EPC STORMWATER REVIEW COMMENTS
IN ORANGE BOXES WITH BLACK TEXT

CITY LINK TRUCKING

Construction Drawings

PCD FILE NO. PPR2339

C1.1

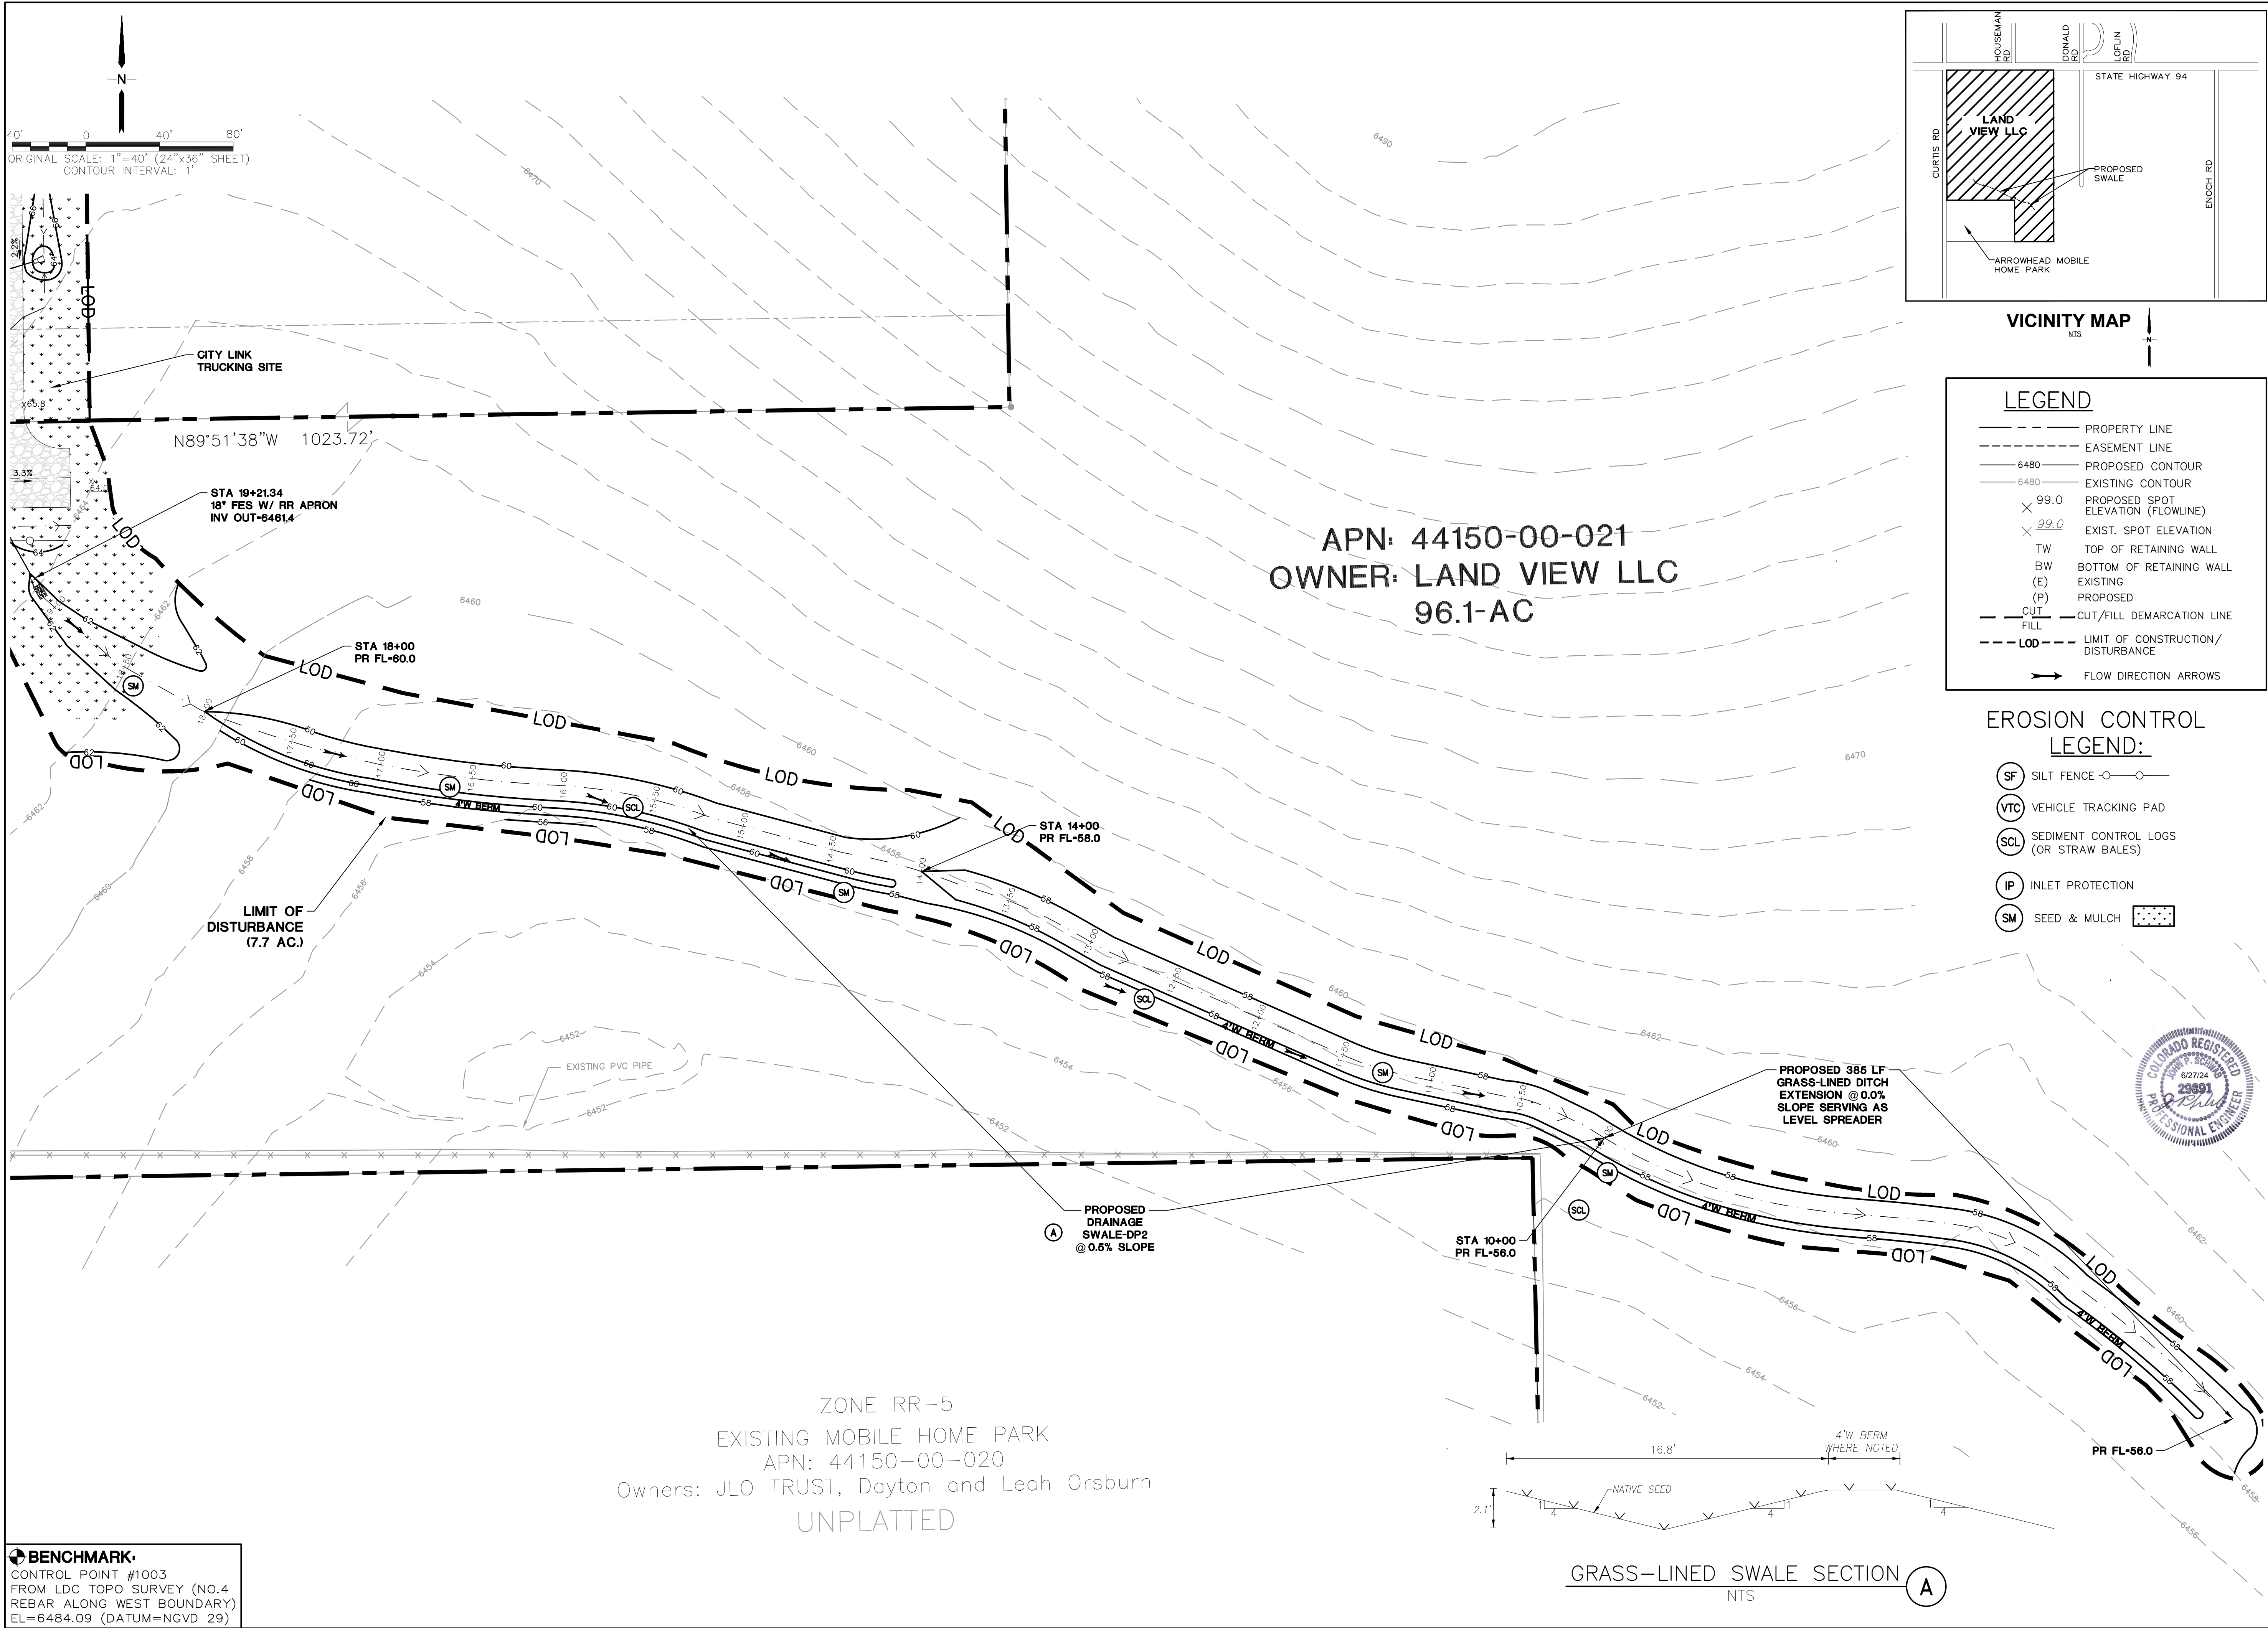
Unresolved from Submittal 1: GEC Checklist Item ee - Plan certified by a CO Registered PE. Each sheet needs to be stamped/signed prior to approval
